RE: Comments Conditional Use Application CU-25-00001 Hayward Well

RE: Comments Conditional Use Application CU-25-00001 Hayward Well

Stephanie Austin  
NoaNet  
OSP Project Manager  
509-481-5054  
saustin@noanet.net

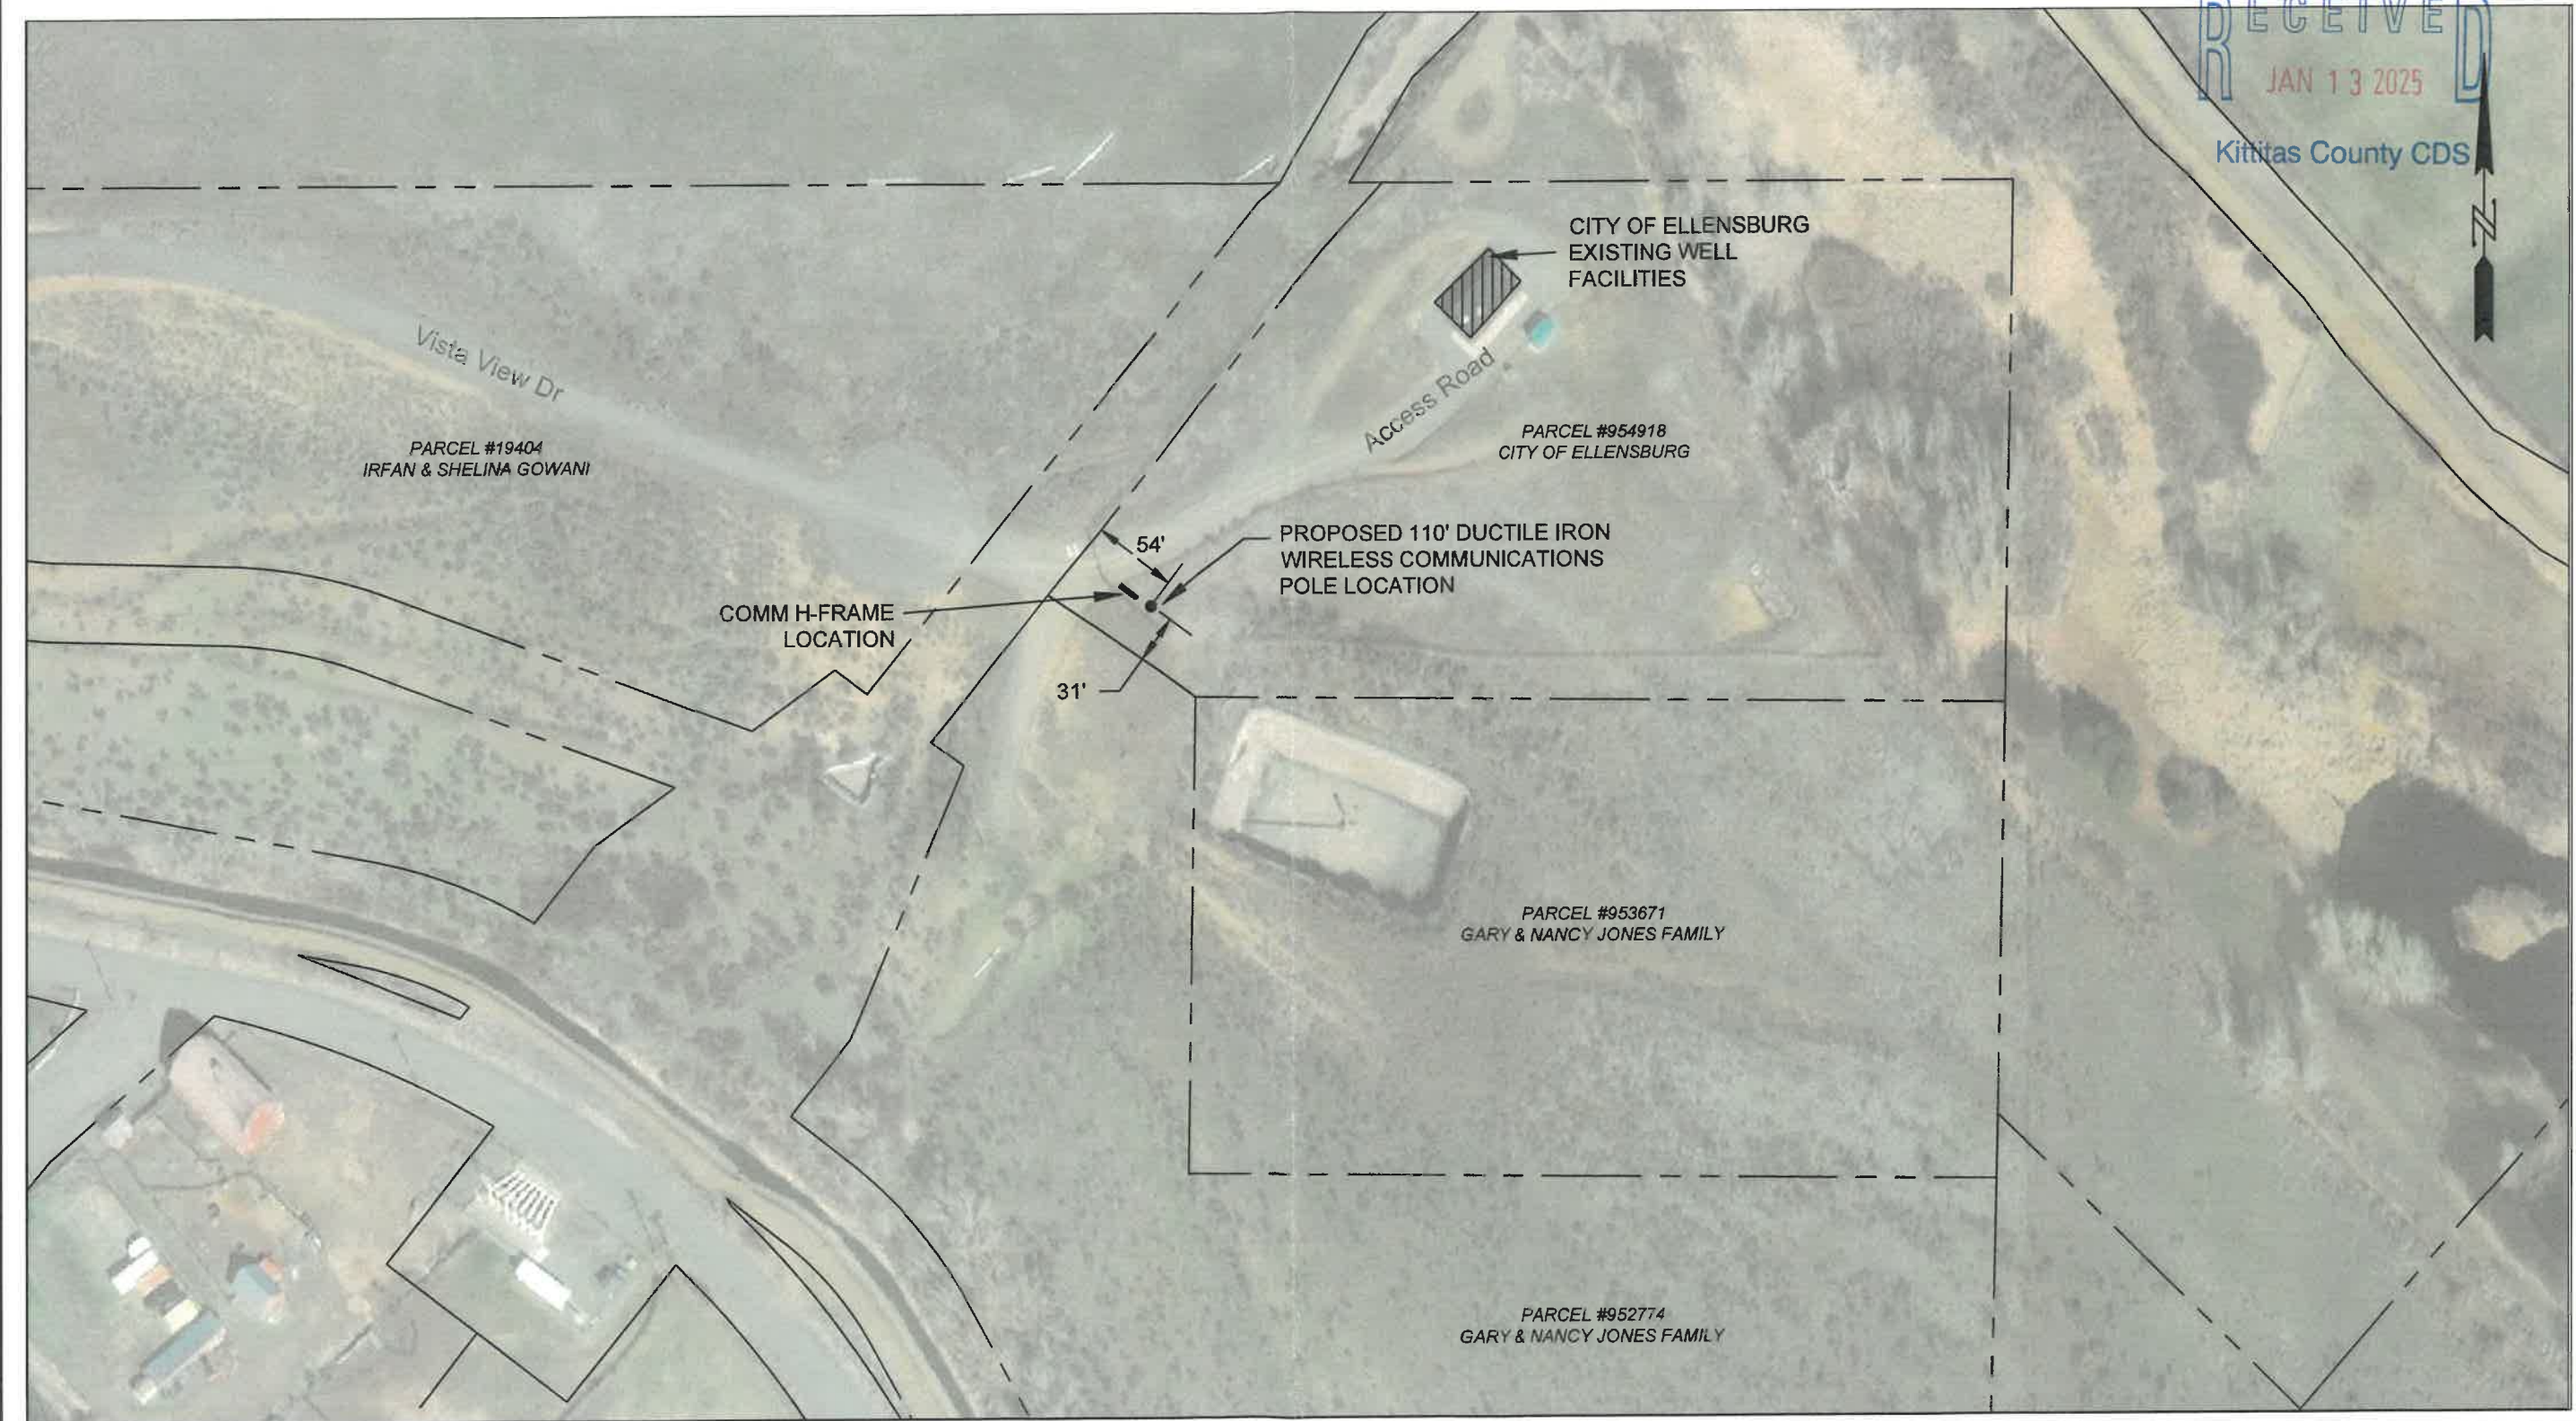
Regarding site access, the city will be working to relocate the gate, with the new gate location still outside the sanitary setback area of the well but will allow for unobstructed access to the tower.
